30 July 2025

RE: Exhibition of State Significant Development Application – Proposed Data Centre Development (SSD-68013714) – Council's Response to Applicant's Submissions Report

**PROPERTY: 43-61 Turner Road, Gregory Hills
Lots 14, 15, 16 and 17 in DP 28024**

1 SITE PLAN
1 : 750

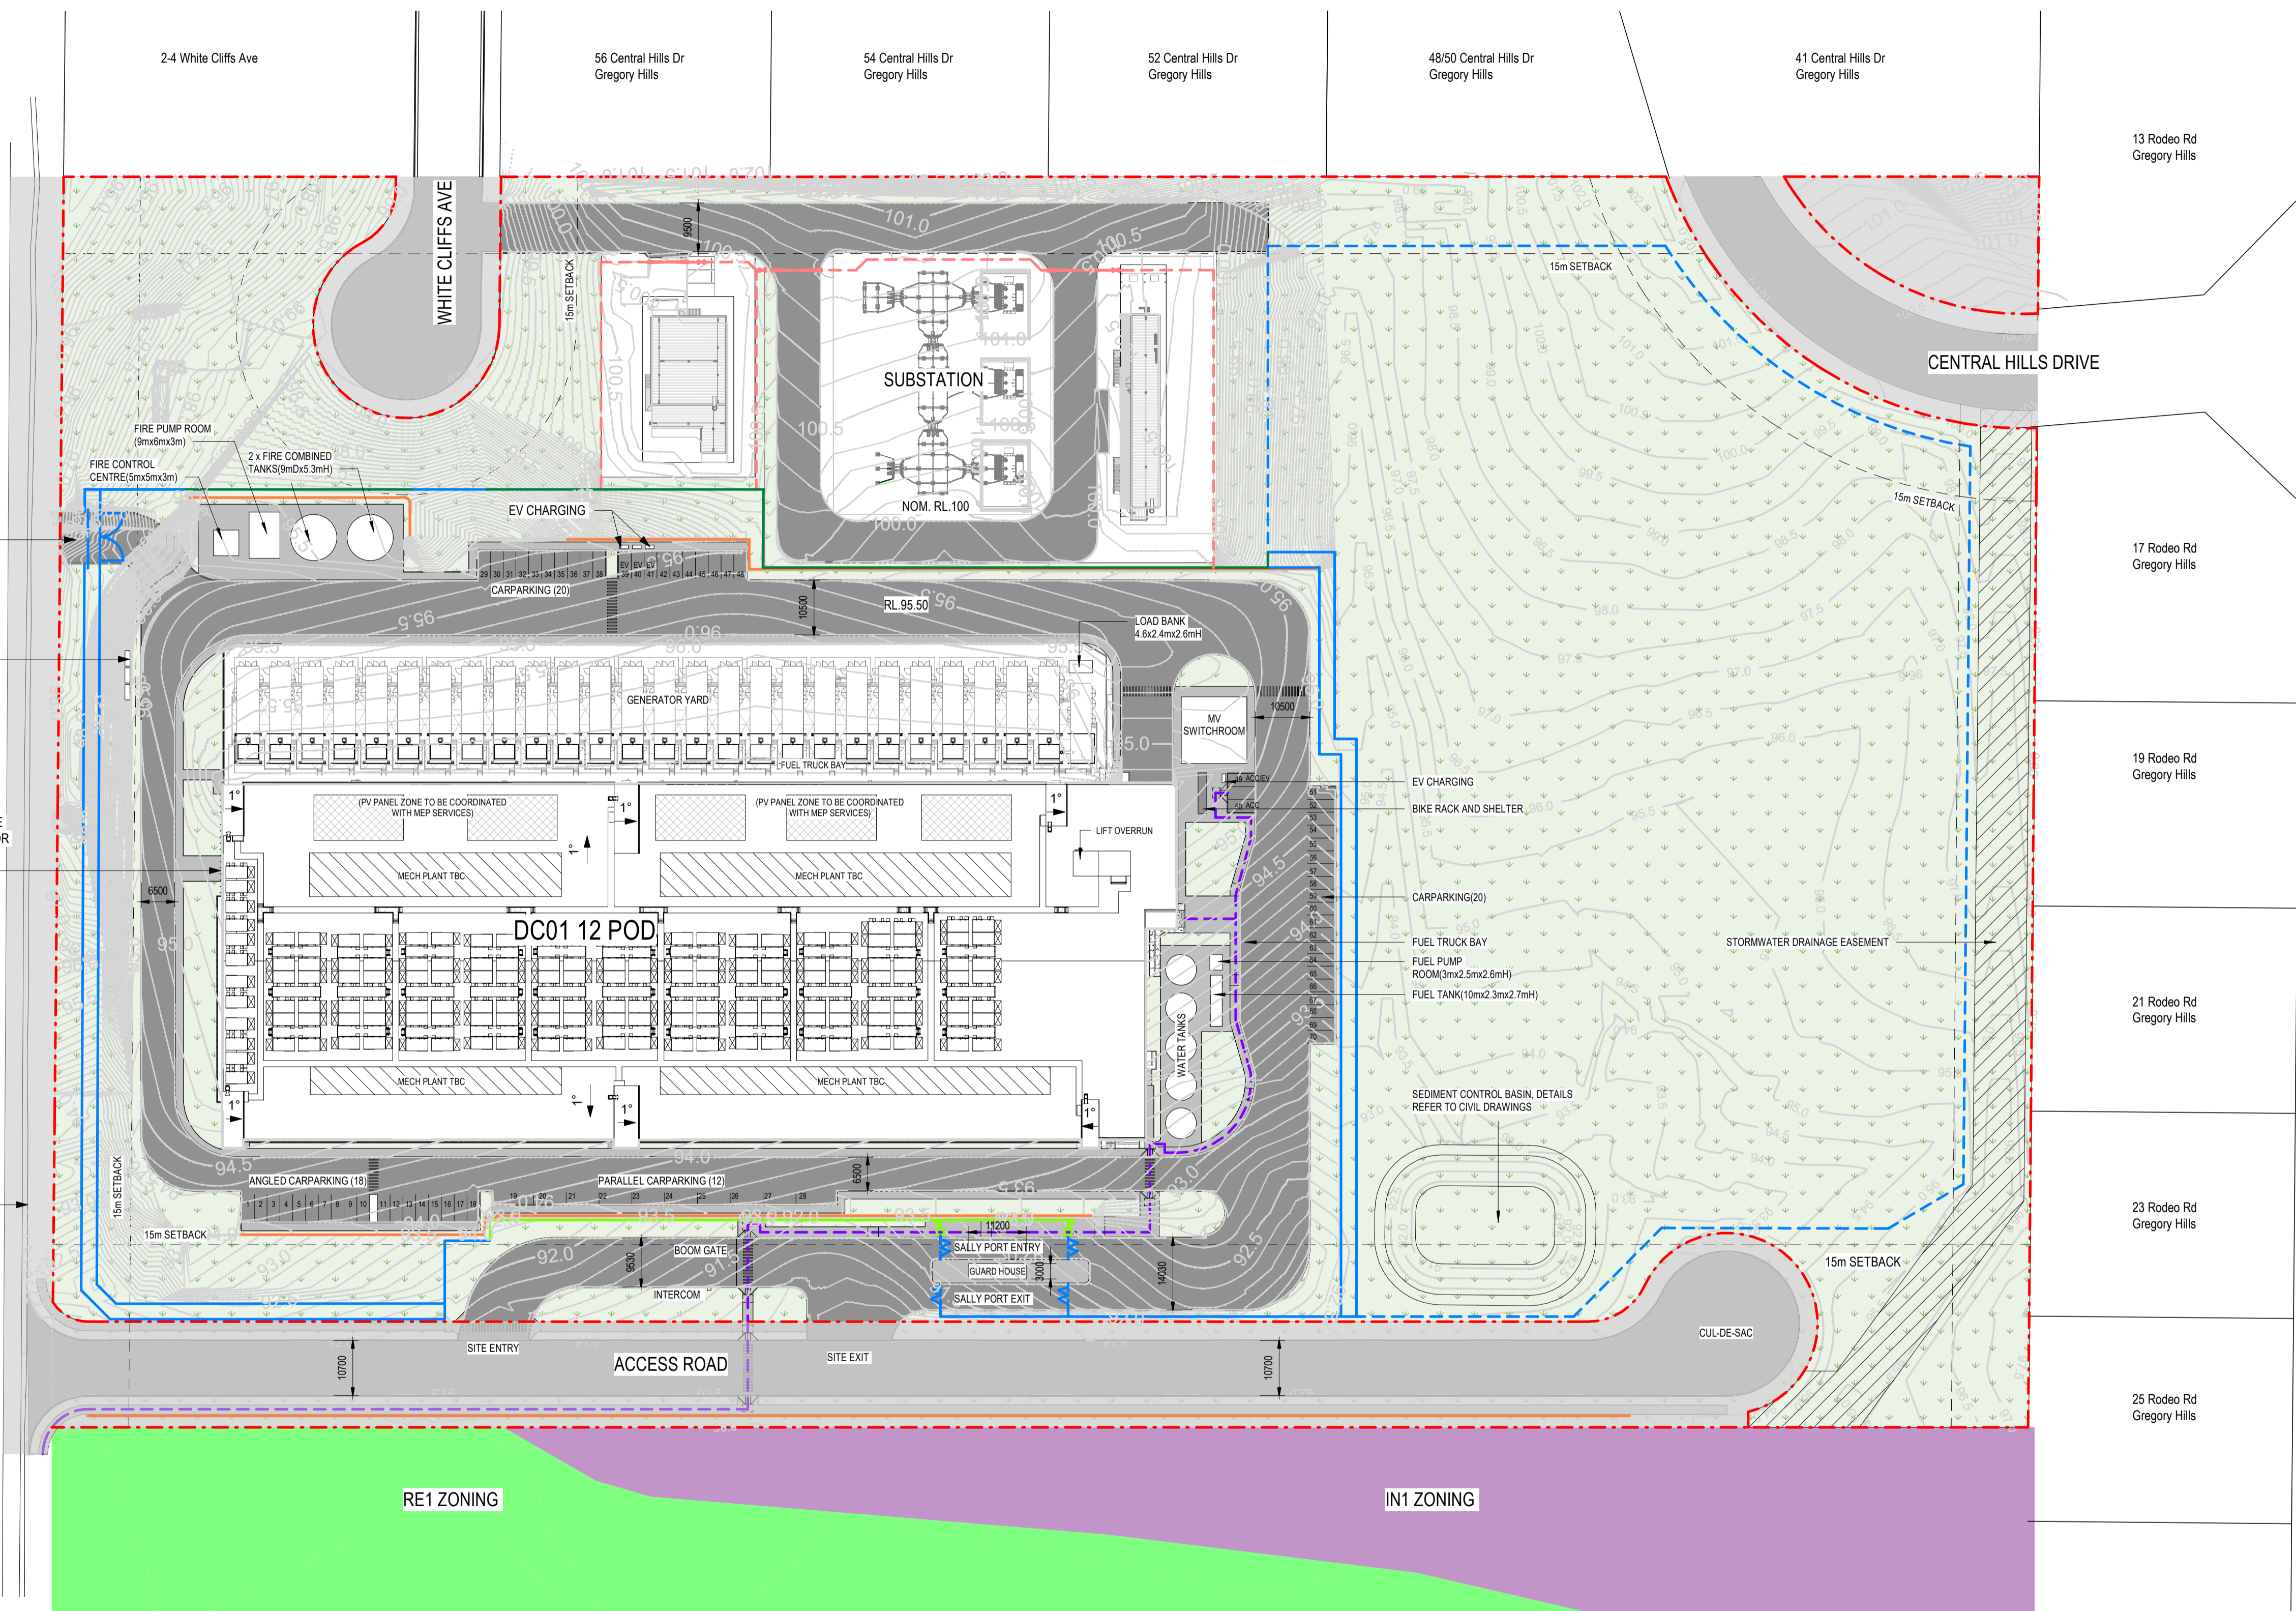
Council notes the proposed substitution of species nominated in its earlier advice for areas of the car park and accepts that these matters may be addressed through the provision of an amended landscape plan to be lodged as part of the Construction Certificate documentation. However, Council maintains its position that opportunities exist to amend the car park design in accordance with the requirements of Camden Council's Development Control Plan 2019, Section 2.18.3 – Car Parking Design Criteria, including:

- a. Provision of a 2.5m wide landscape bay between every 6-8 car parking spaces,
- b. Provide a minimum 1m landscaping strip at the end of parking aisles, and
- c. Be landscaped generally in accordance with Figure 2-12 of the CDCP.

These amendments will maximise shading opportunities throughout the car parking area in an environment that can the subject to extremely high air temperatures given its location in South West Sydney and reducing the heat island effect is a matter that should be further considered.

1 SSDA - SECTION A - DC01
1:300

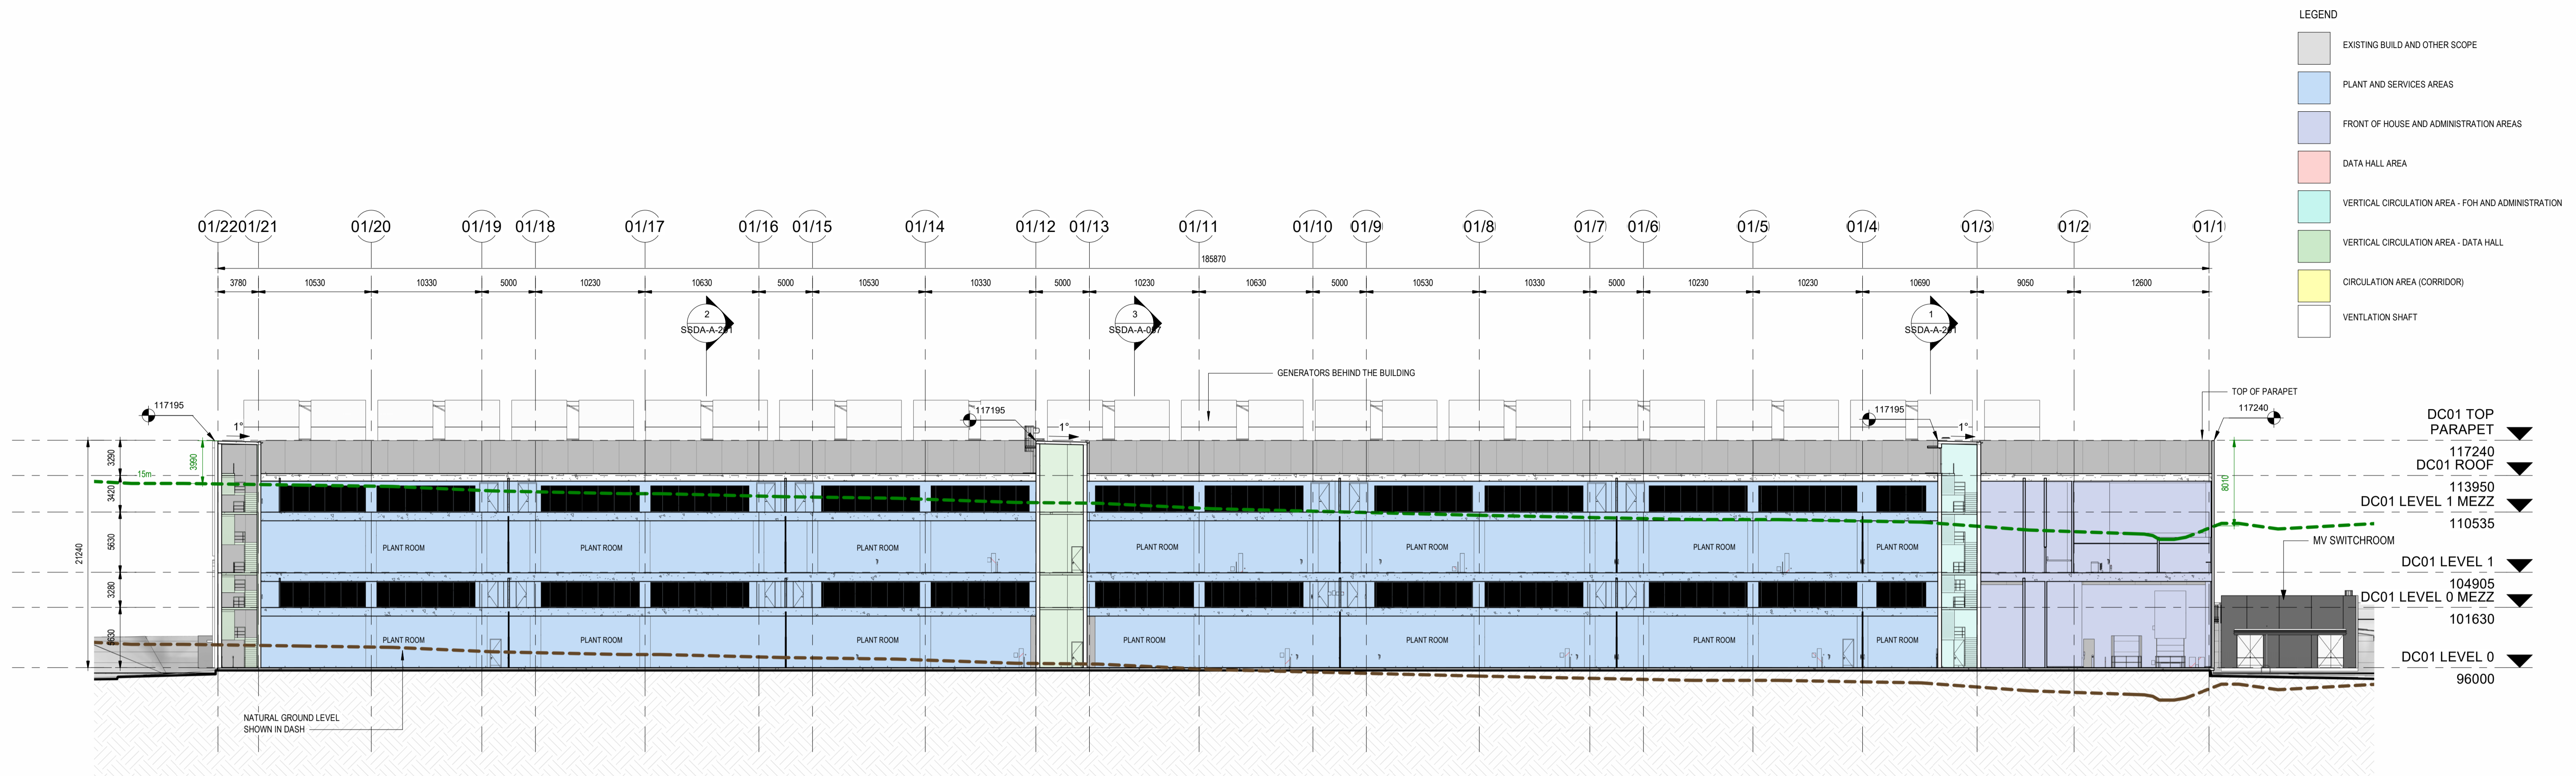
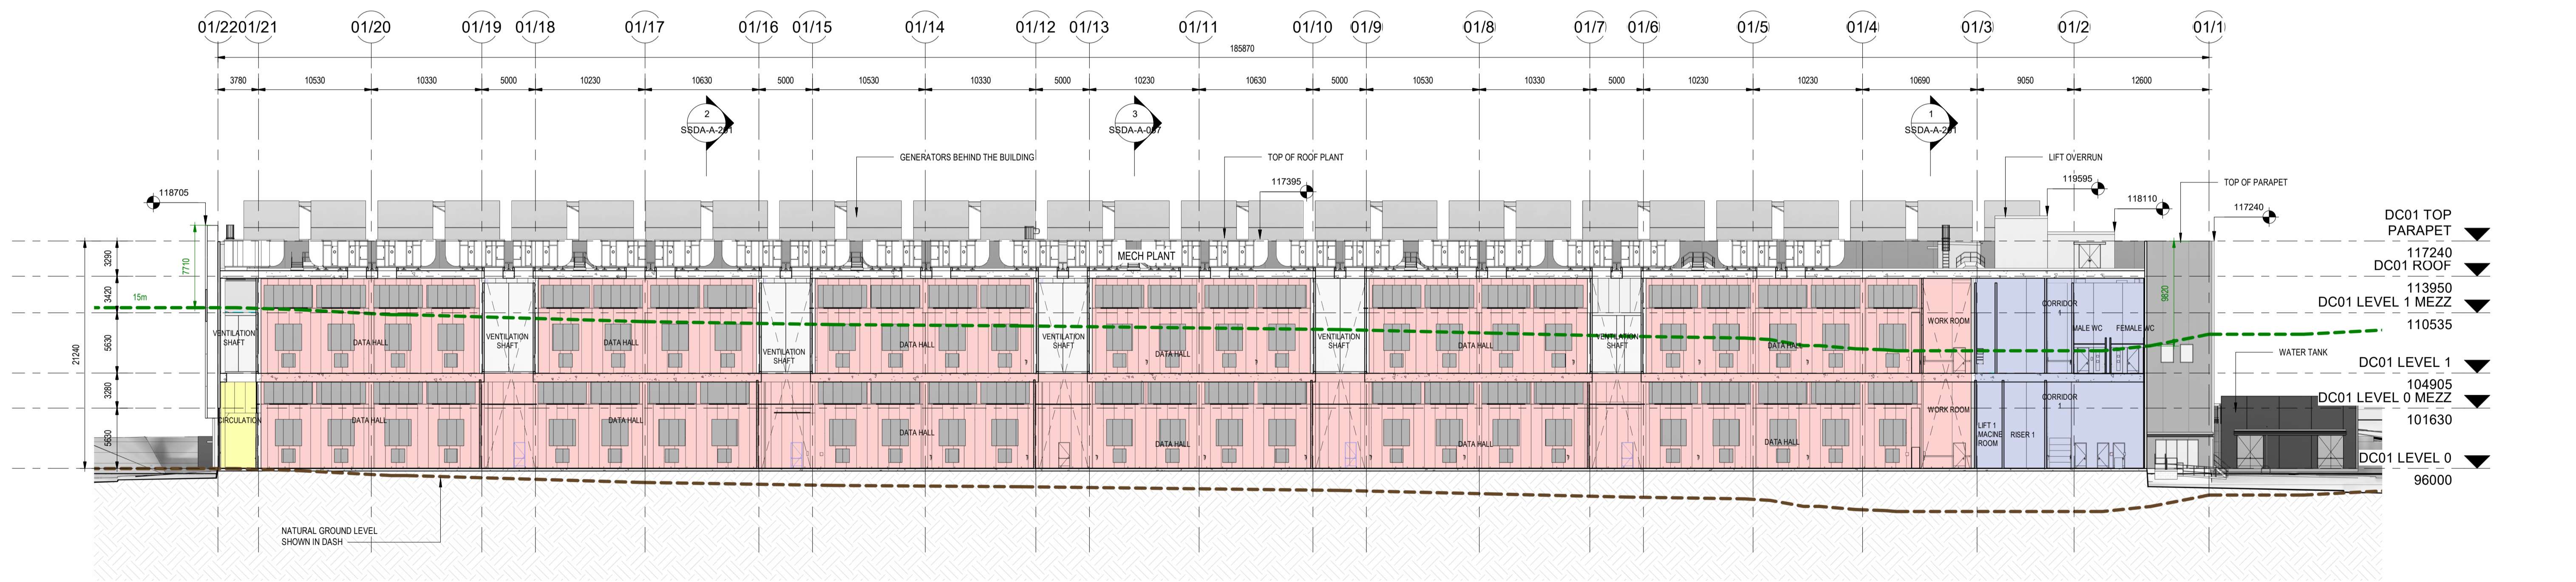
It is noted that the proposed development has a maximum building height up to 23 metres and thereby contravenes the maximum prescribed building height development standard of 15m.

Council's previous response requested that the Department closely consider the Clause 4.6 written request to determine if the development standard is "unreasonable or unnecessary" in the circumstances of the case and whether there are sufficient environmental planning grounds to justify the contravention. These comments remain applicable.
